From: ENVU Biodiversity and Land Use
Sent: 16 February 2026 12:42
To: Nicole Helliwell
Cc: Planning ContactCentre
Subject: doc 2025/92915 at location Land at, Jill Lane, Mirfield, WF14 0DR

I understand that this is to review the discharge of conditions 13, and 18 from an ecological perspective in 2023/93067.

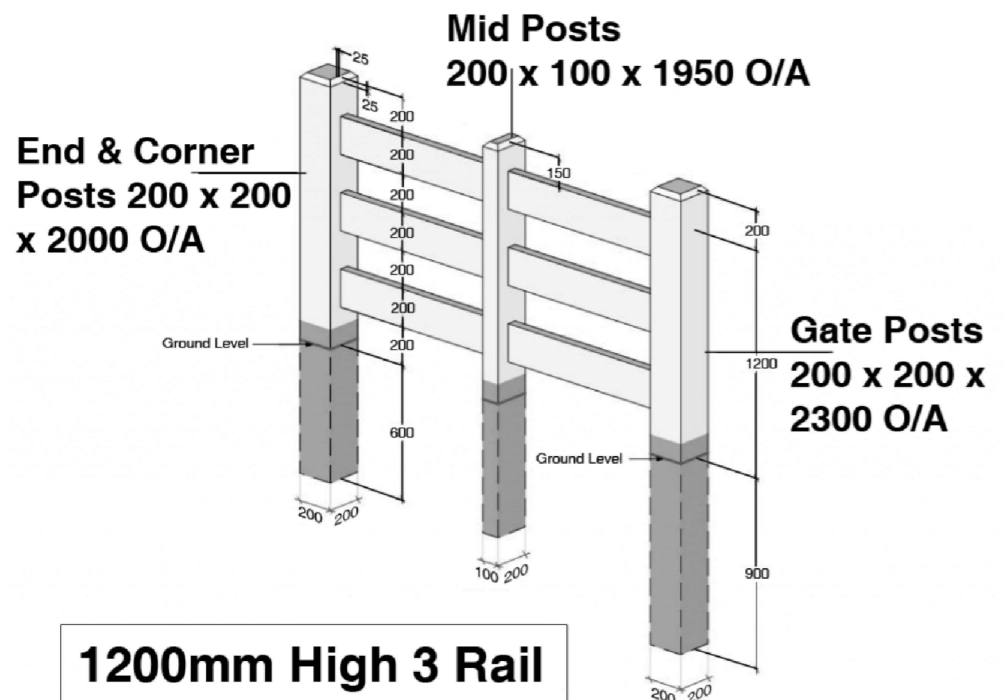
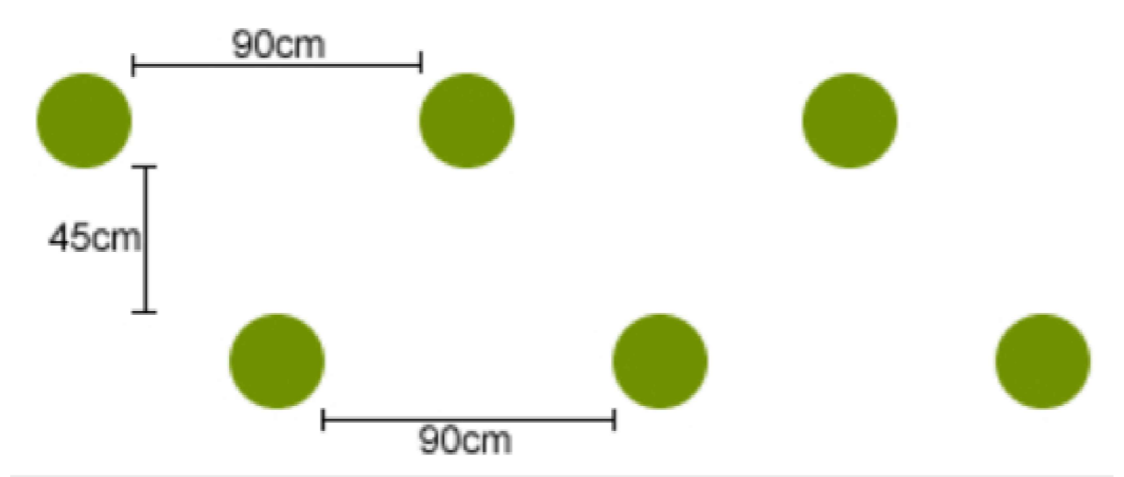
The "Layout for conditions no, 5 & 18 . 2023/62/93067/E drawing" has been reviewed. This is acceptable and in line with the requirements of the condition.

Condition 18 is met form an ecological perspective.
